MEMORANDUM

Subject: PA23-026- Cornelius LaceyPRD – Technical Review 1

The following are responses to your comment letter addressed to Ryan Larsen for the above referenced project dated December 7, 2023:

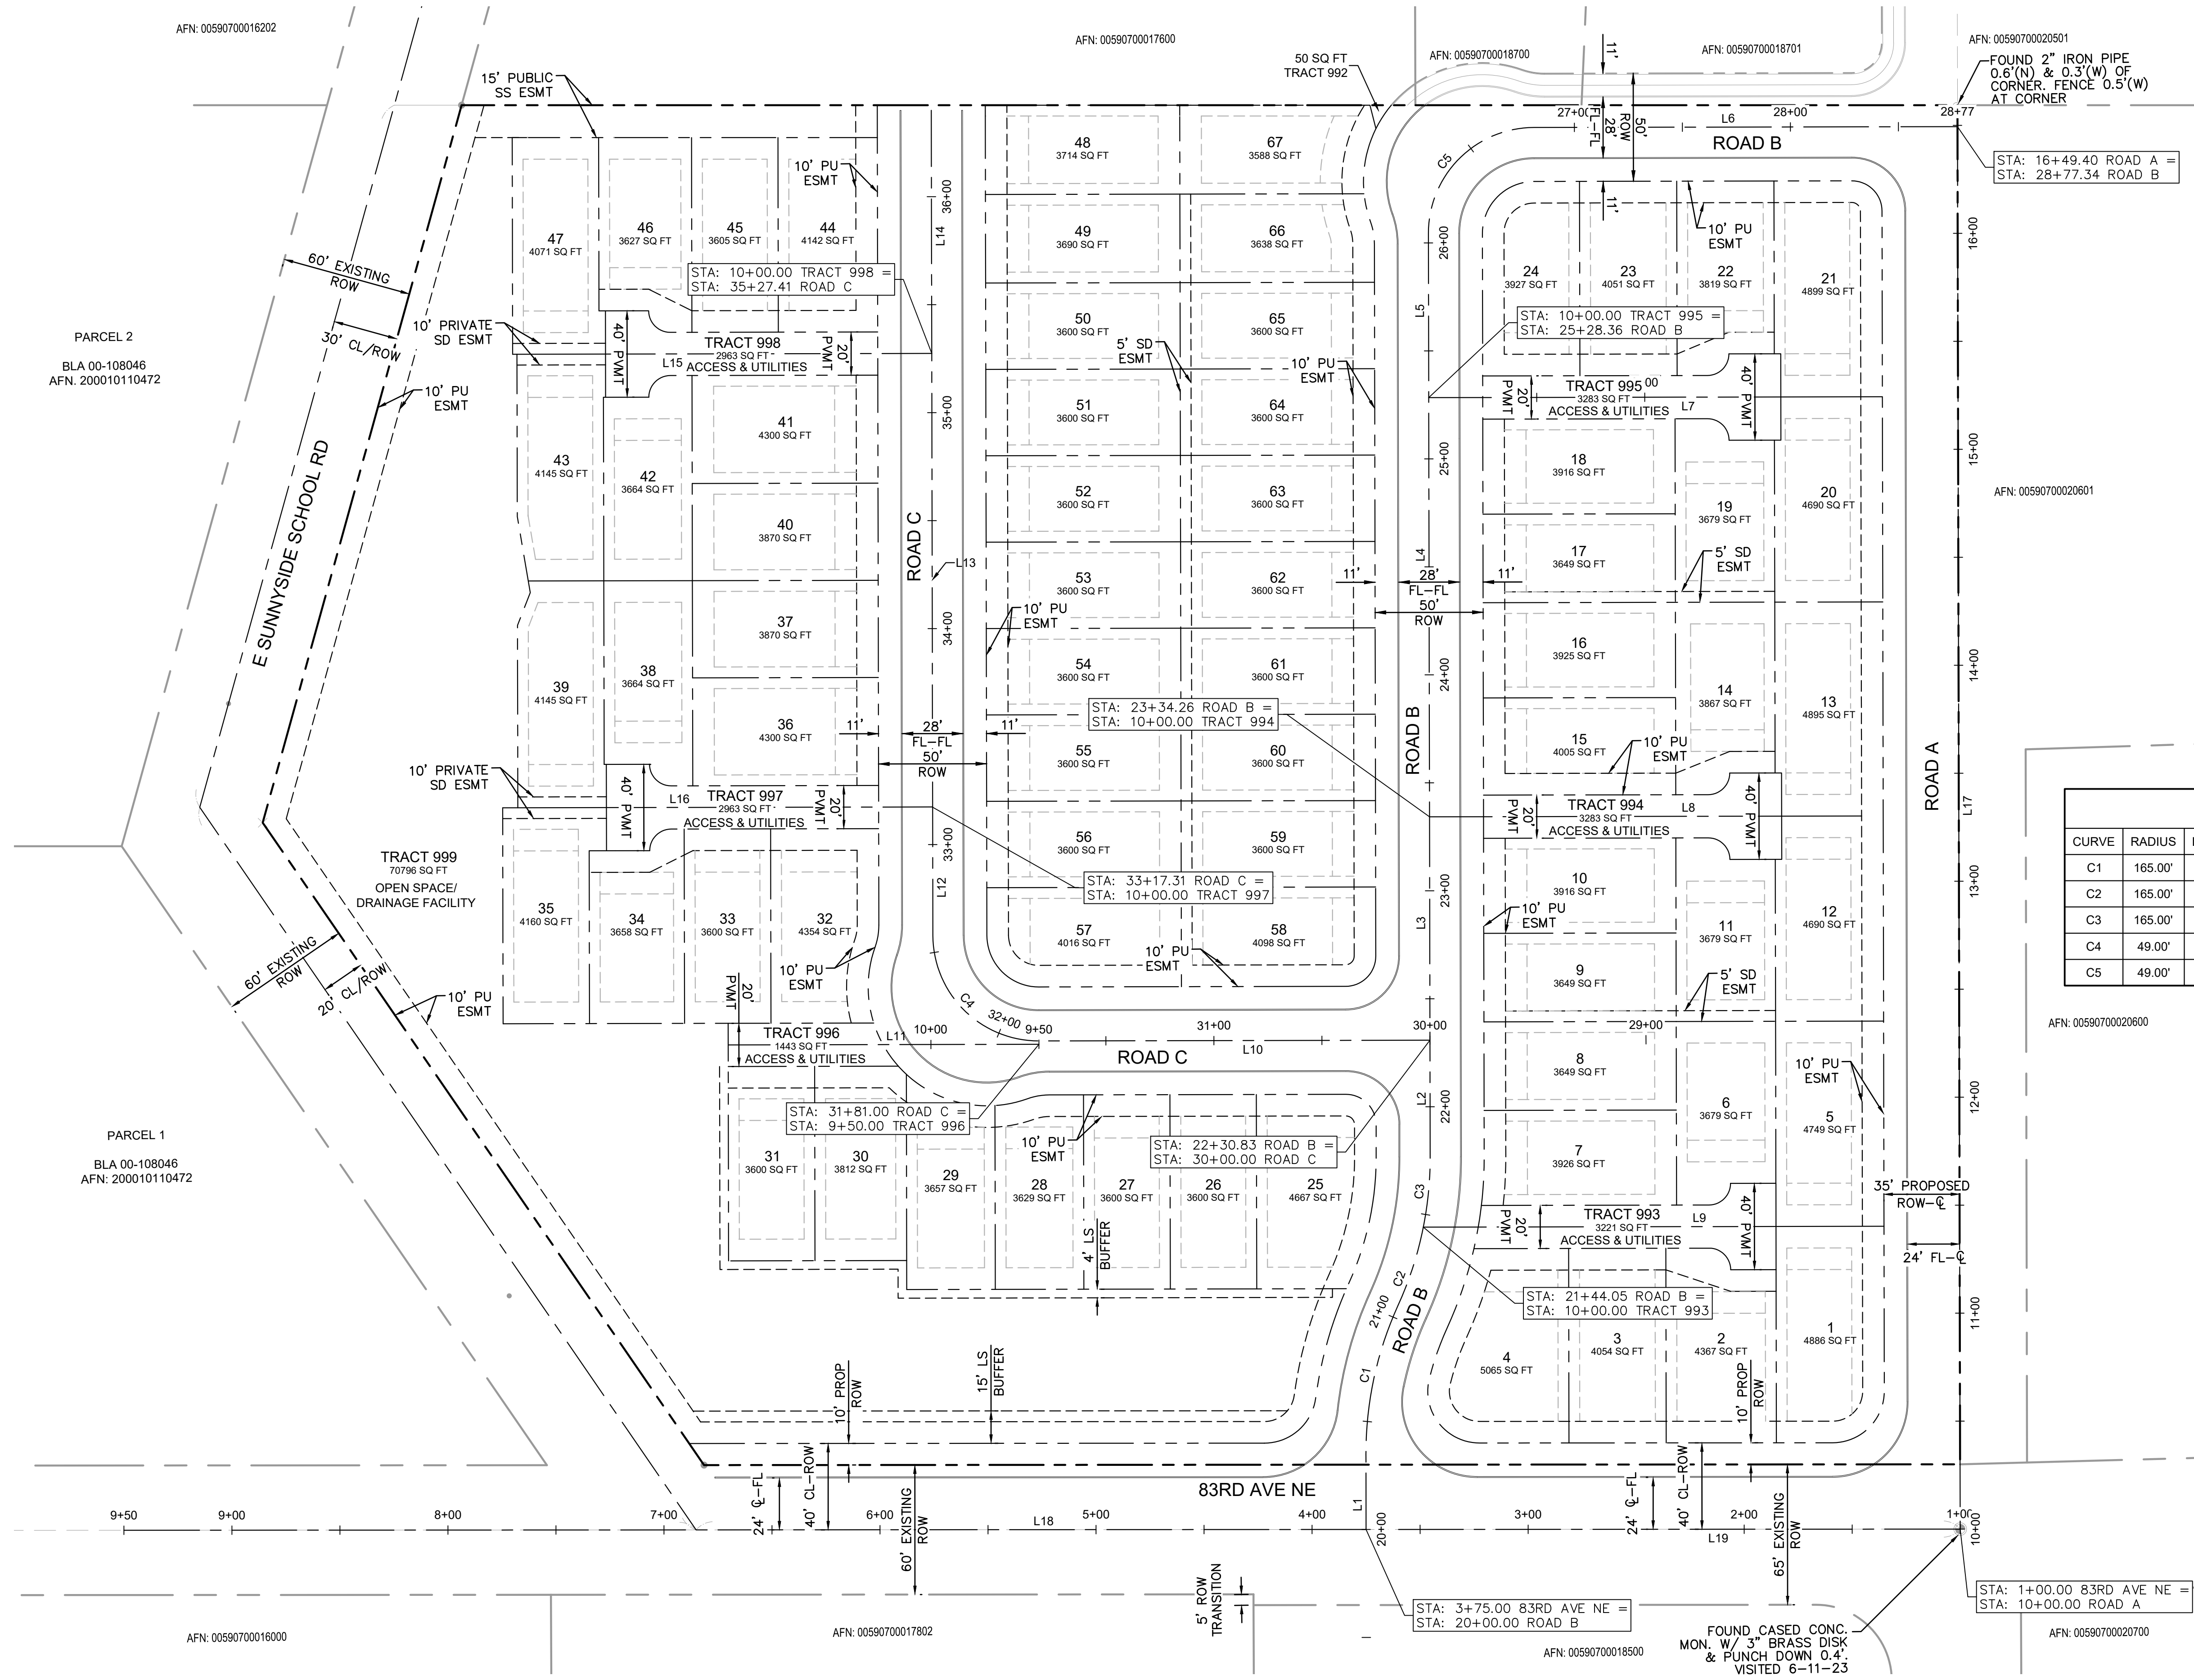
Comment 1: [MMC 22G.090.560](#) requires that the design and development of subdivisions attempt to preserve the topography of the site by selection and location of buildings which fit the natural slope of the land. As proposed, with multiple areas/lots proposed to have retaining walls ranging from 3 to over 8 feet in height, it does not appear the proposal meets this requirement. Walls proposed strictly to obtain flat lots will not be permitted. Other alternatives (i.e. tuck-under house plans) should be implemented to reduce/eliminate wall height.

Comment 2: Pursuant to [MMC 22D.050.030\(4\)\(e\)](#), if retaining walls taller than four feet are used, and are visible from the street or adjacent property, they shall be terraced so that no

individual segment is taller than four feet. Any walls ultimately permitted exceeding 4 feet shall comply with these requirements.

Comment 3: The future 44th Street extension is a designated minor arterial. The side yard setback on arterials is 15 feet. This setback applies to all lots adjacent to 44th Street. Please revise site plan(s) accordingly.

Response: Walkout lots have been added to various locations across the site to reduce walls and follow existing site topography. Where walkout lots were not feasible, lots were graded with a stepped foundation. These lots have 4 feet of fall from front of lot to back of lot, with a 4 foot wall at the back of lot as well, which results in 8 feet of fall across the length of the lot. This style of grading can be seen in lots 25-31.

Response: Where ever feasible walls were limited to 4 feet. Walls that are taller are behind homes or will be screened with landscaping so they can't be seen from Public ROW or adjacent property.

Response: Addressed, there is a 15' side yard setback from 44th street to lots 1, 5, 12, 13, 20, and 21. There is a 10' Public Utility Easement labeled from the Right-of-way, as well as an additional 5' offset from the PUE line to the building footprint.

DRAWING TITLE:
LANDSCAPE PLAN
APPLICANT:
KM CAPITAL, LLC
C/O LAND PRO GROUP INC.
10515 20TH STREET SE, SUITE 202
LAKE STEVENS, WA 98258
(425) 231-2718

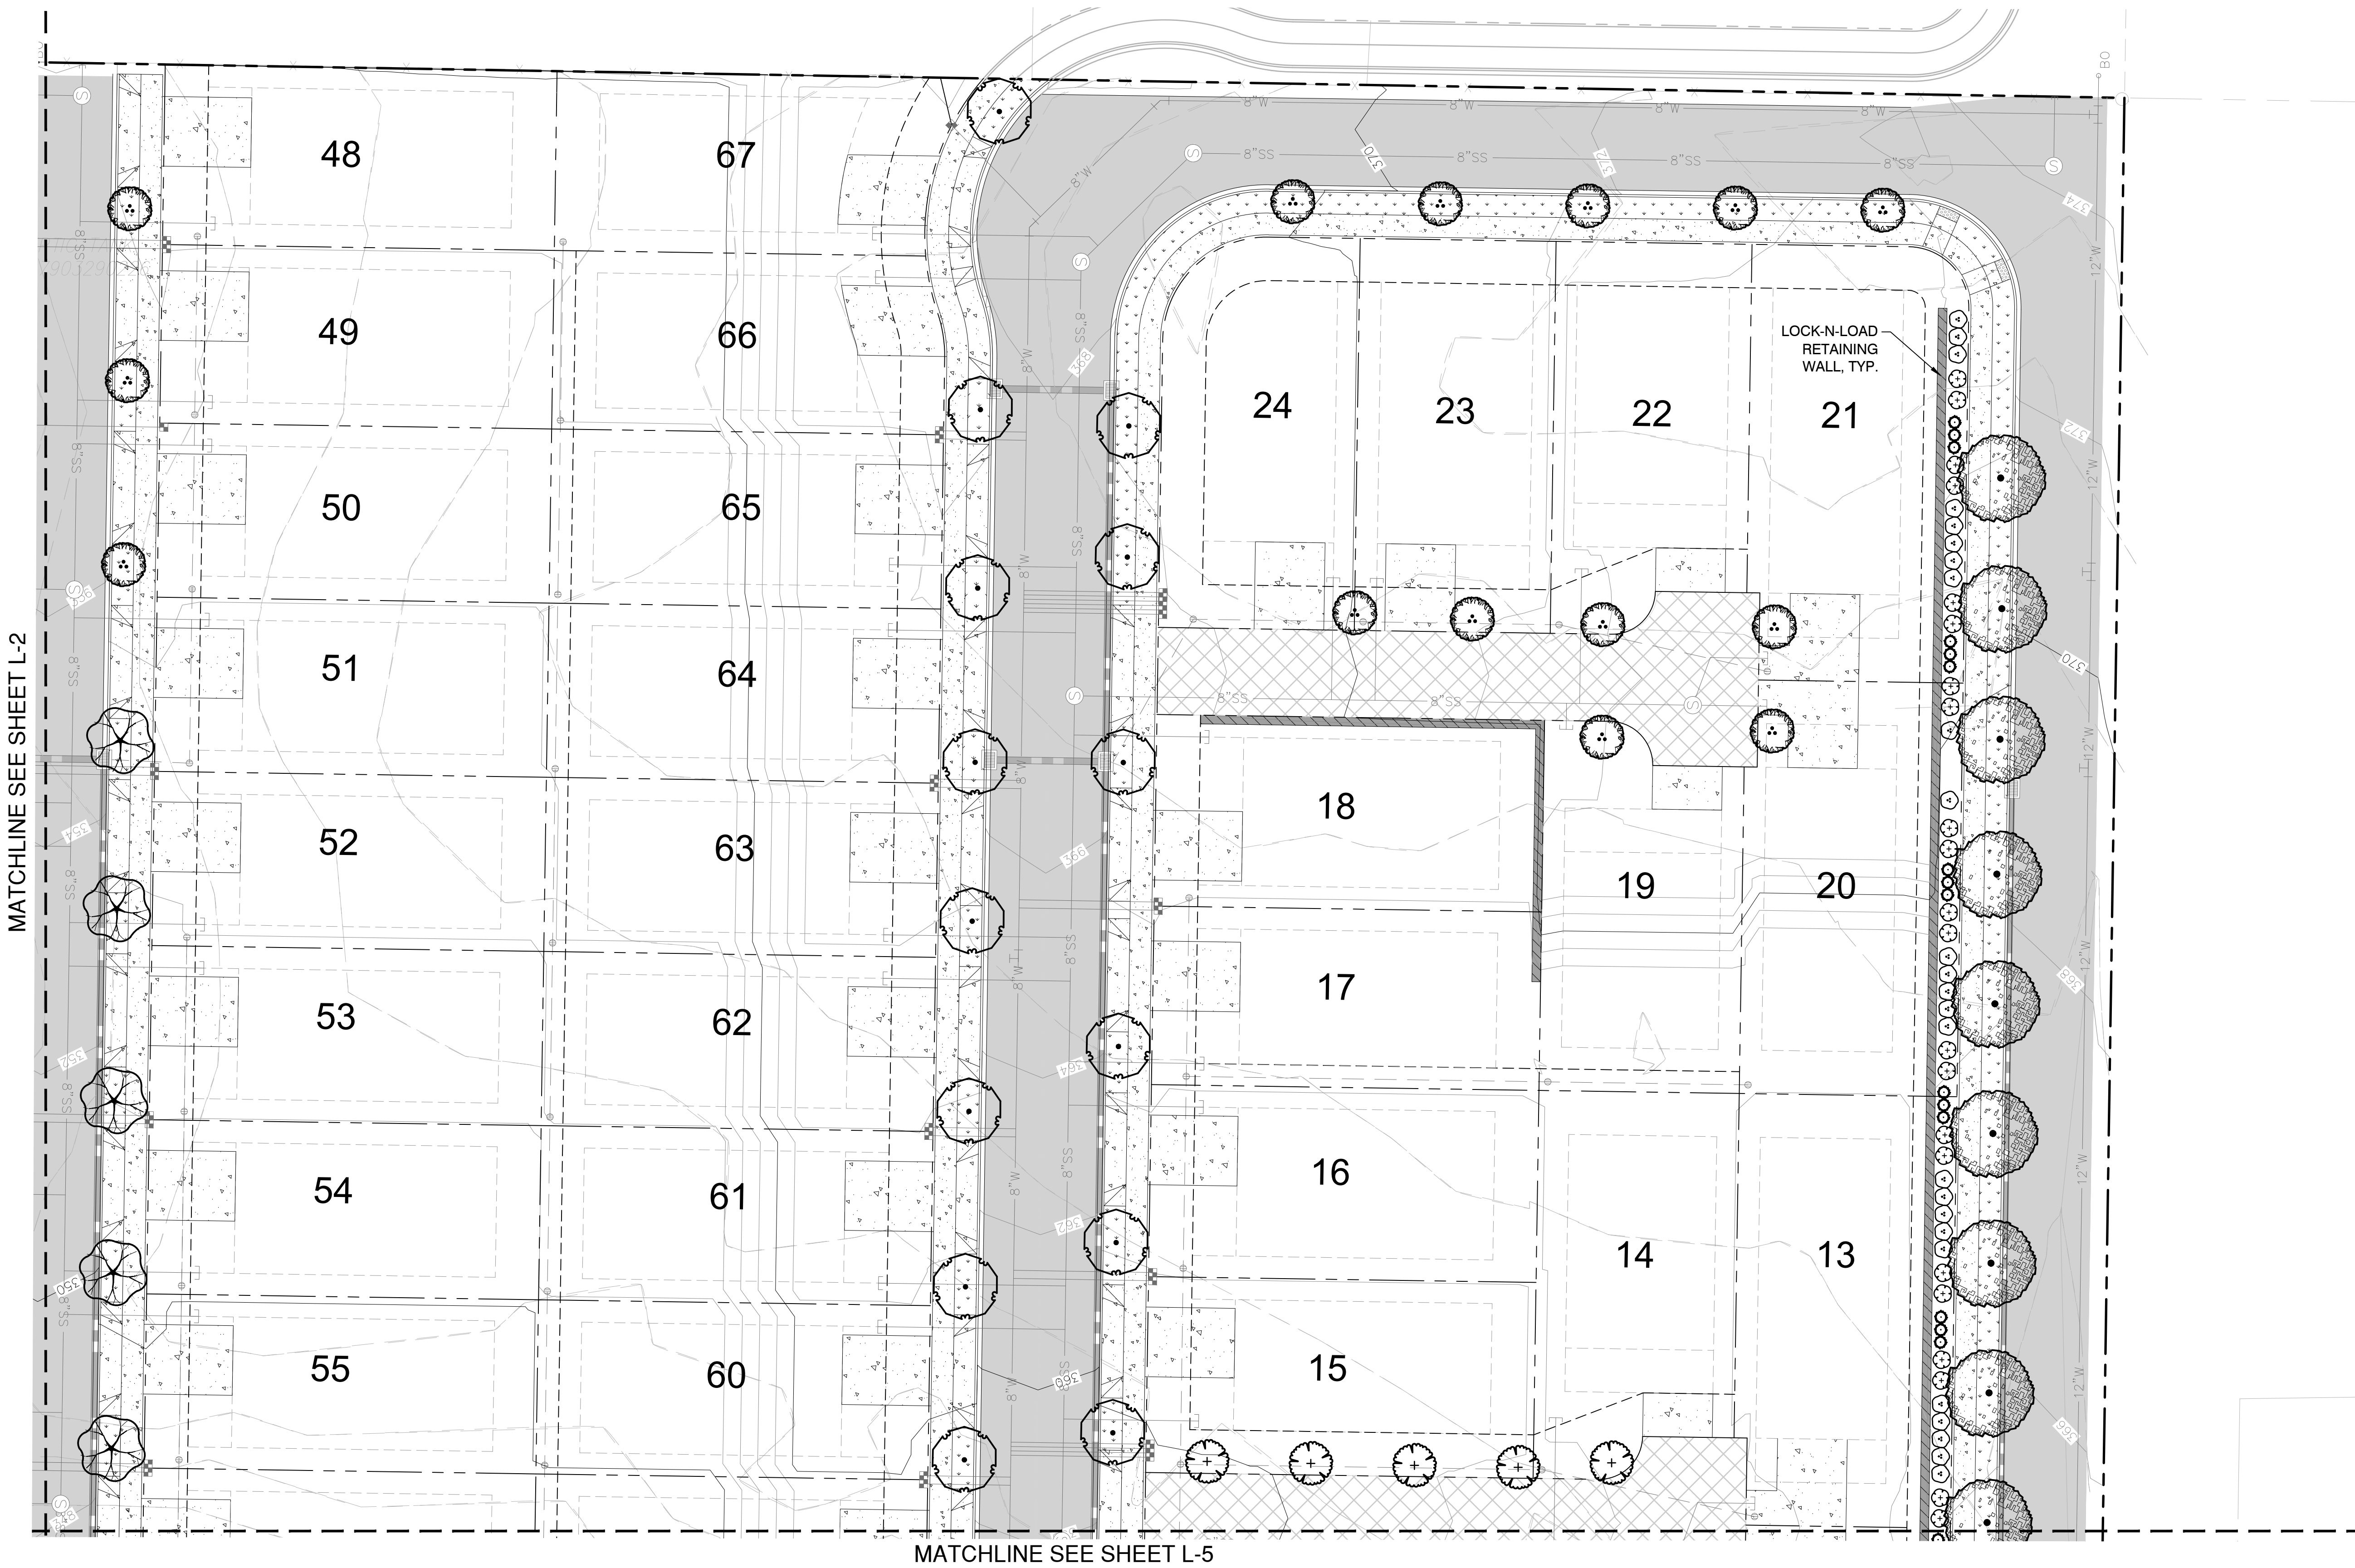
Comment 9: A final landscape plan shall be required to be approved, prior to civil construction plan approval, and designed to comply with the applicable provisions outlined in [MMC Chapter 22C.120, Landscaping and Screening](#).

9.1. Location of precast vault lids need to be shown as well as proposed access to said lids.

9.2. Ensure compliance with the fencing/screening standards of [East Sunnyside Whiskey Ridge Design Standards](#).

Comment 10: All stormwater management facilities, including vaults, are required to be screened with a 5-foot type L1 buffer.

Response: Location of precast vault lids are shown on the plan and can be accessed.

Response: Fencing/screening standards have been addressed

Response: Stormwater management facilities have been screened with min. 5' type L1 buffer.
